State of Washington
DEPARTMENT OF FISH AND WILDLIFE

November 1, 2023

SUBJECT: SP-23-00009 Sparks

BOWERS ROAD SHORT PLAT
 PART OF SECTION 26, T. 18 N., R. 18 E., W.M.
 KITTITAS COUNTY, WASHINGTON

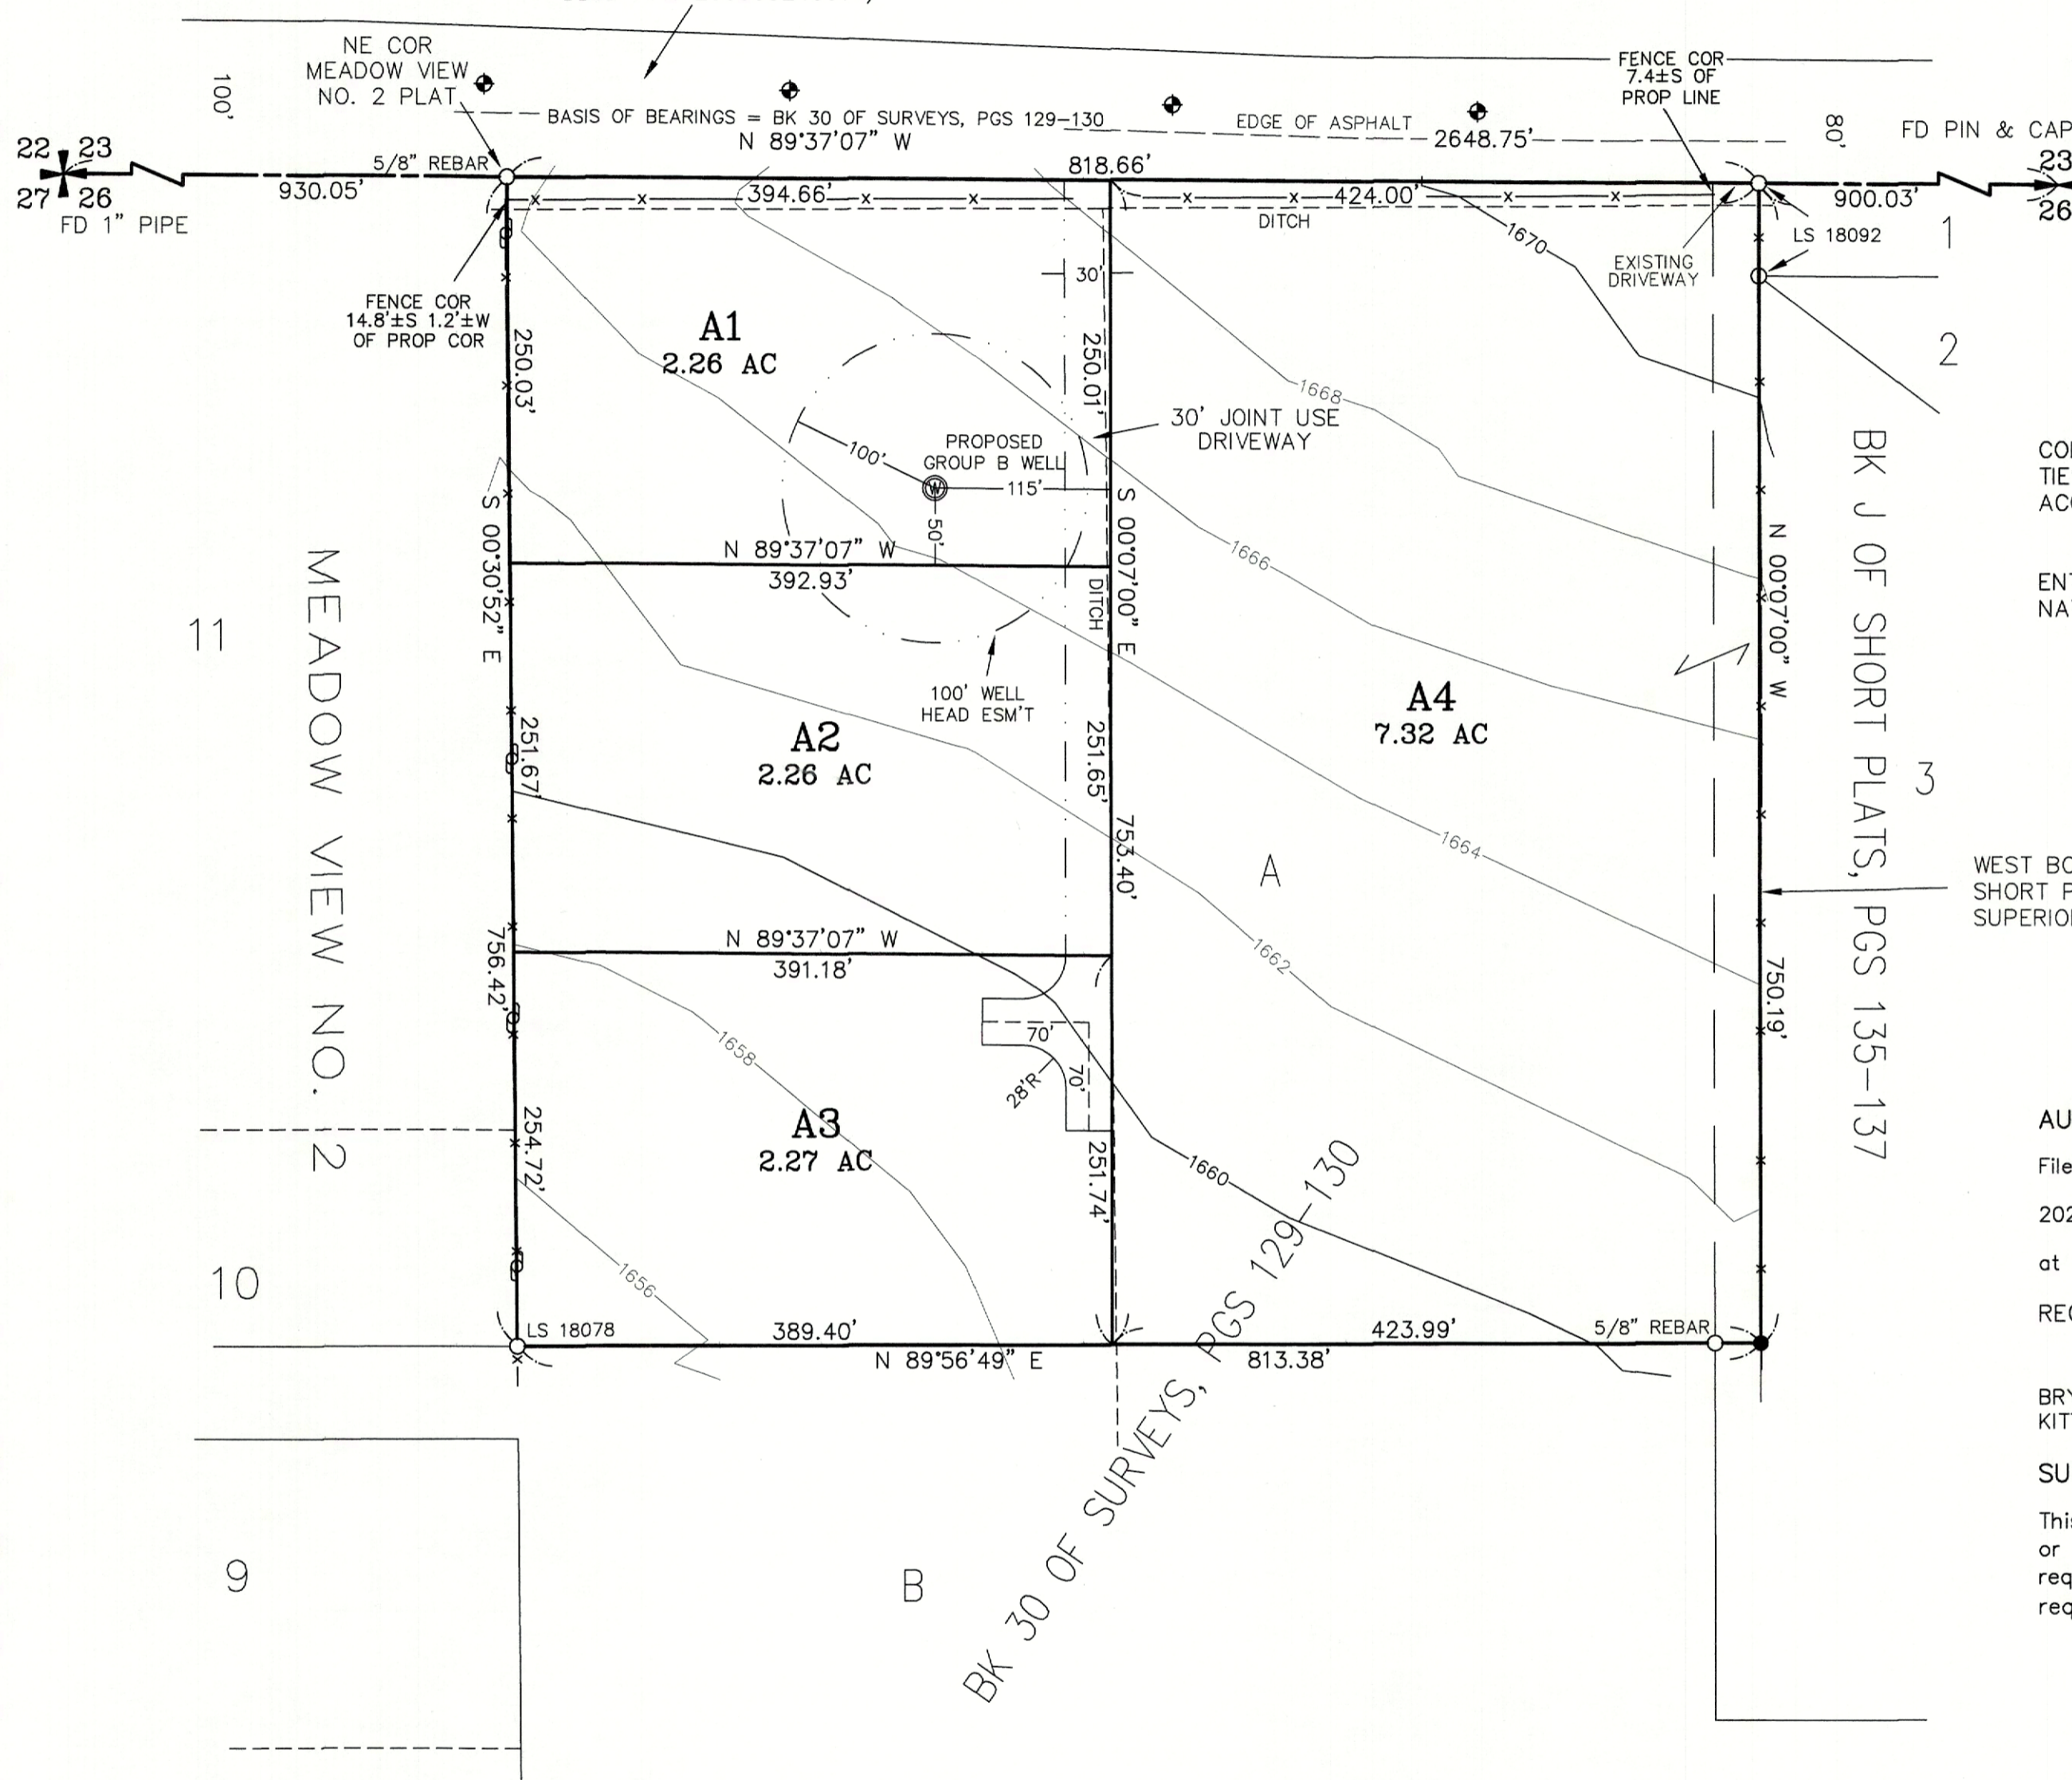
The parcel is not within FEMA's regulatory floodplain, but it is not without flood risk. It is not uncommon for irrigation conveyance ditches to convey floodwater during flood events. We note that the proposed shared driveway easement near the middle of the existing parcel currently has a ditch running north to south. As the driveway is built out and parcels are developed, mitigation measures for water conveyance through the irrigation ditches should be considered to minimize flood risk to future infrastructure.

The WDFW recommends an updated critical area report and a water conveyance plan prior to approval of this short plat. Please feel free to contact me at (509) 961-6639 or Jennifer.nelson@dfw.wa.gov with any questions about these comments.

## **WETLAND INVENTORY OF STARLIGHT PROPERTY Ellensburg, Washington**

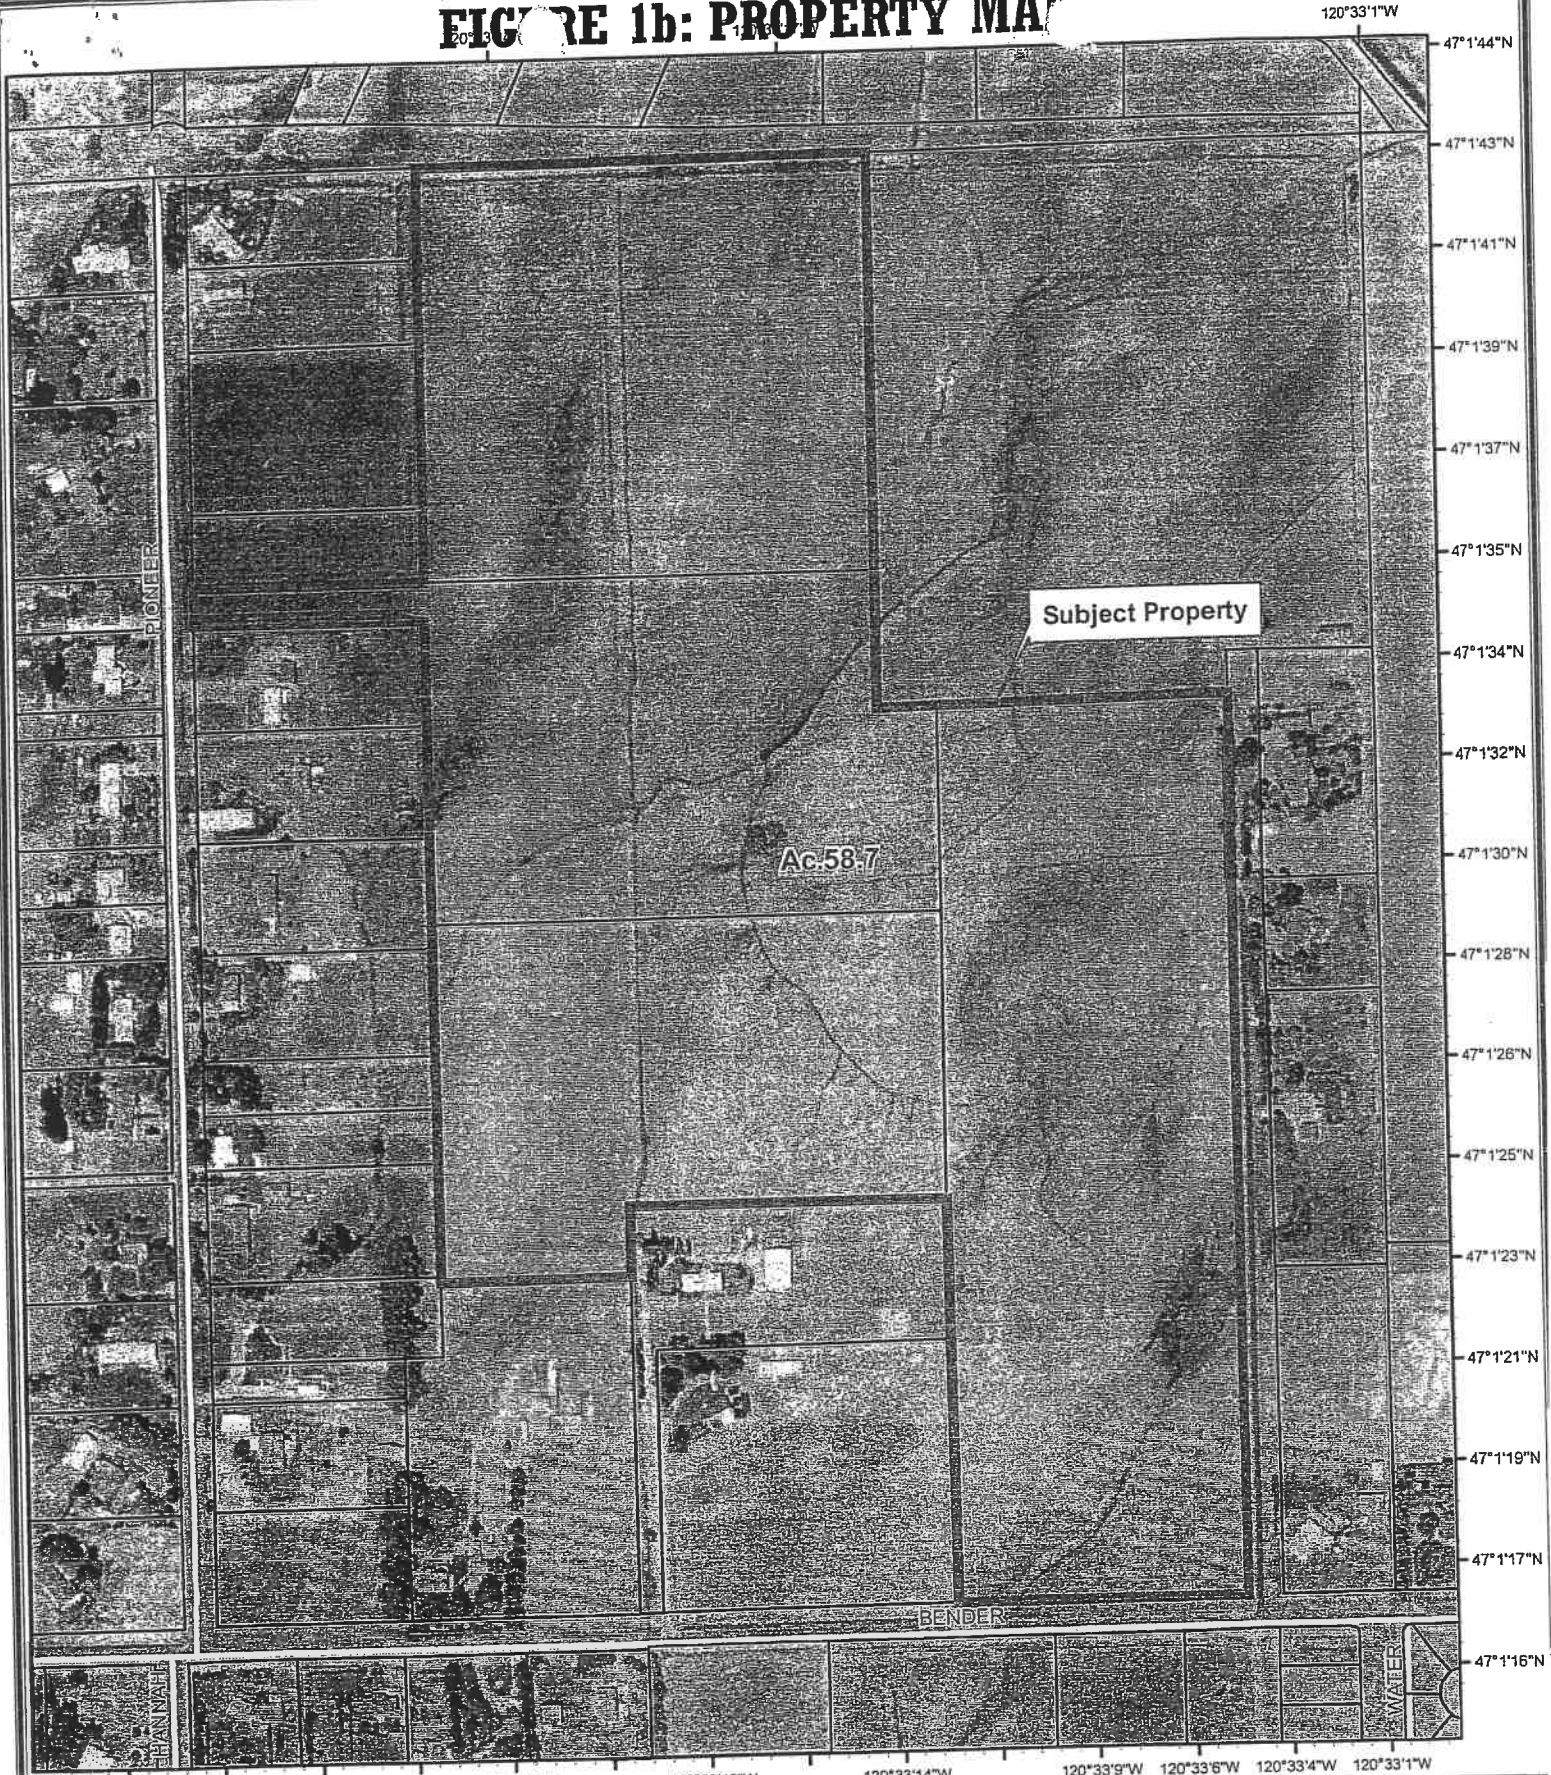
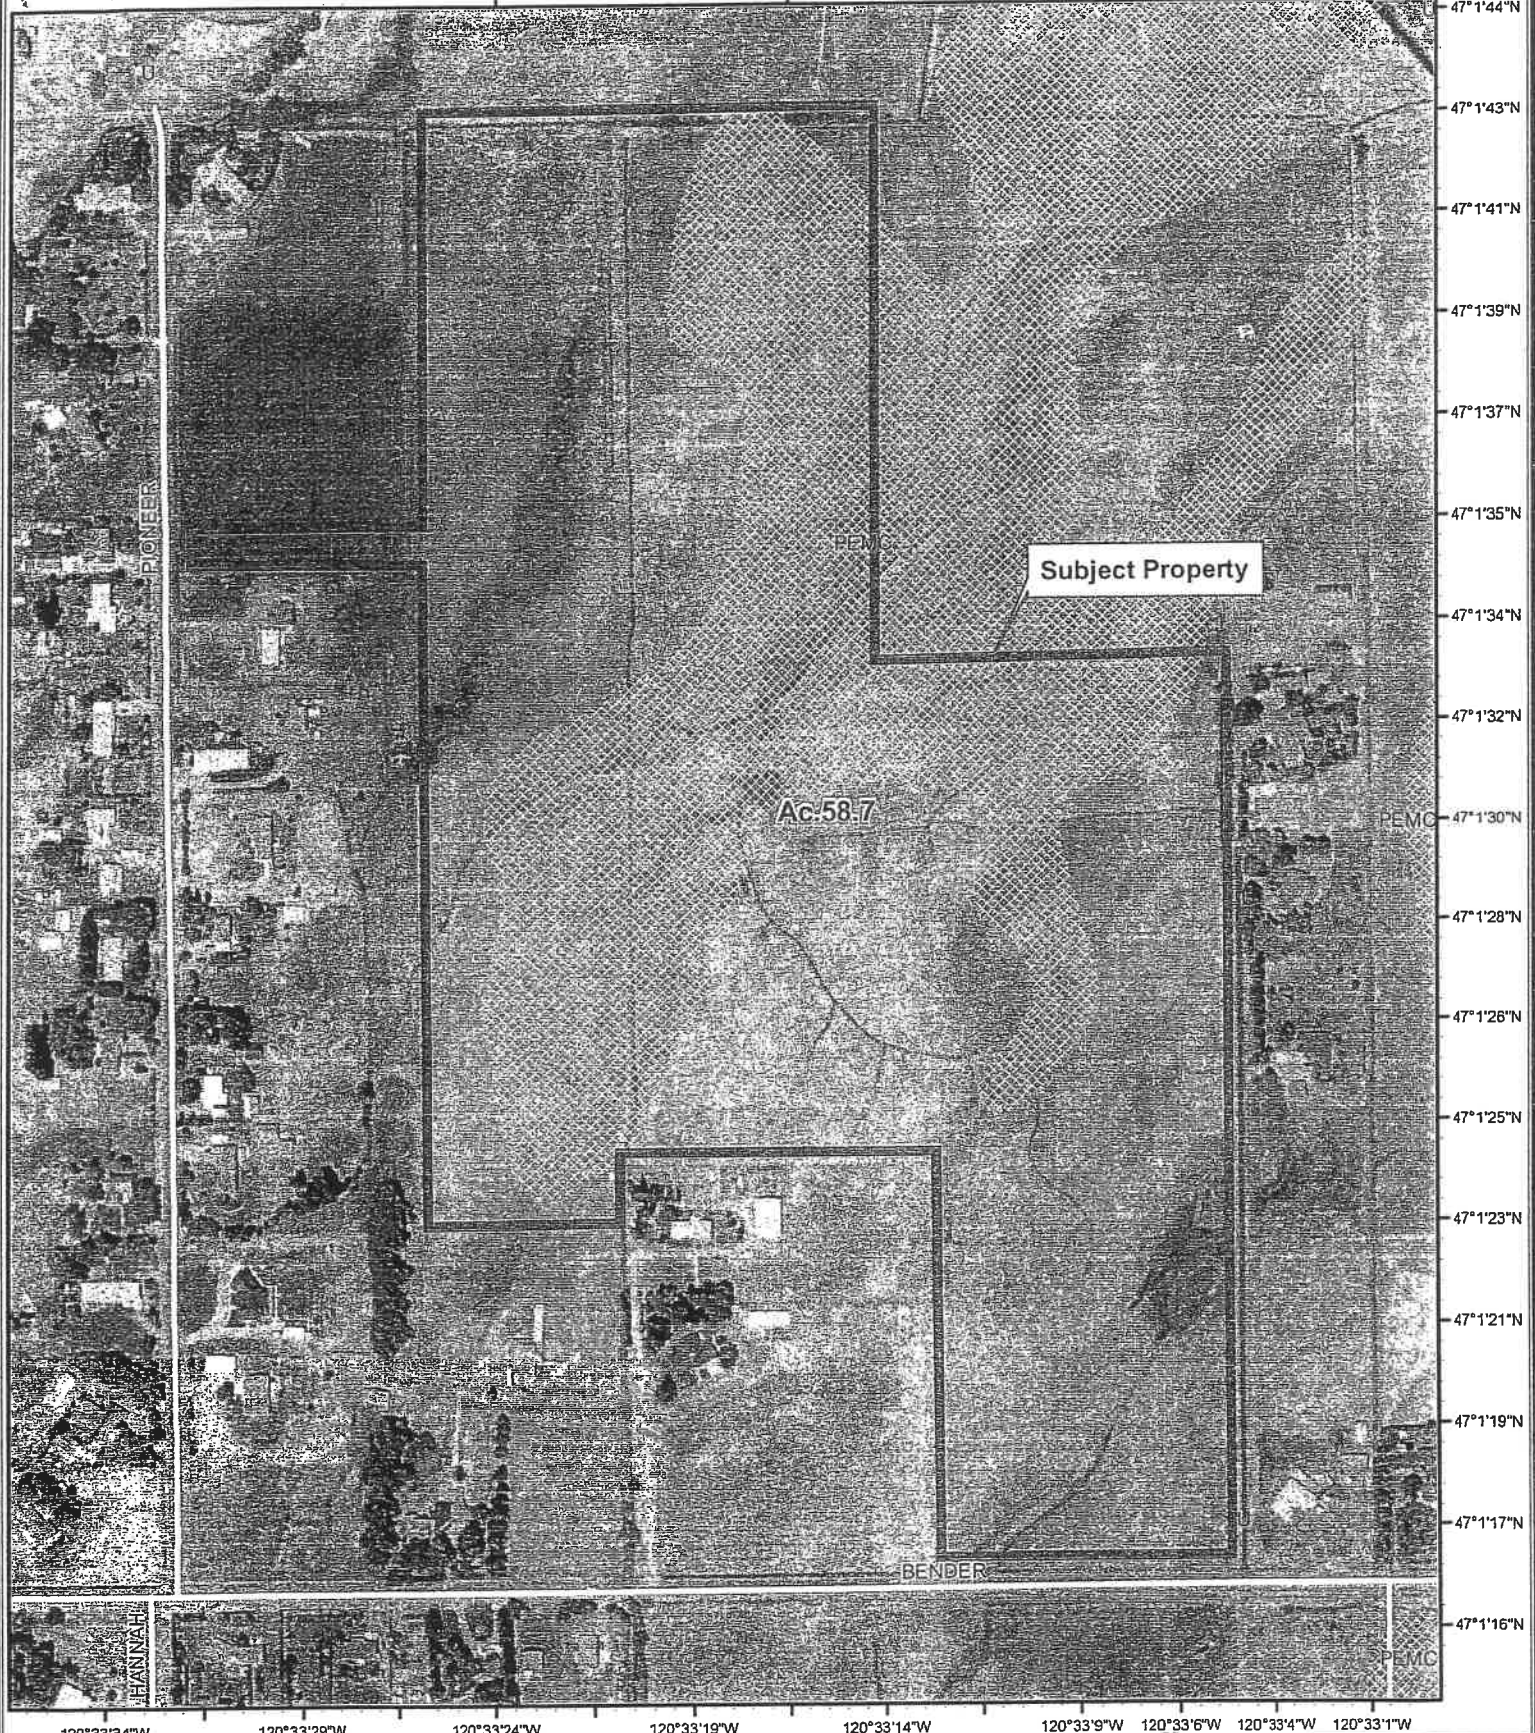
We appreciate the wetlands inventory report being made available for review, but the report was created in 2006 with survey work occurring during the winter months. This report is not relevant for determining whether wetlands are present on the site. Wetlands provide critical habitat for numerous fish and wildlife species, and particularly nesting shorebirds during the spring and early summer months in the Kittitas Valley. Whiskey Creek is a fish bearing stream located northwest of the project area so it is possible there are stream-associated wetlands nearby. We acknowledge the Cascade Irrigation District's canal is also located north of the property and provides irrigation water to the parcel that may result in irrigation induced wetlands. The information provided to date does not provide sufficient information about the potential for wetlands and how they may or may not impact future buildable spaces and/or septic locations.
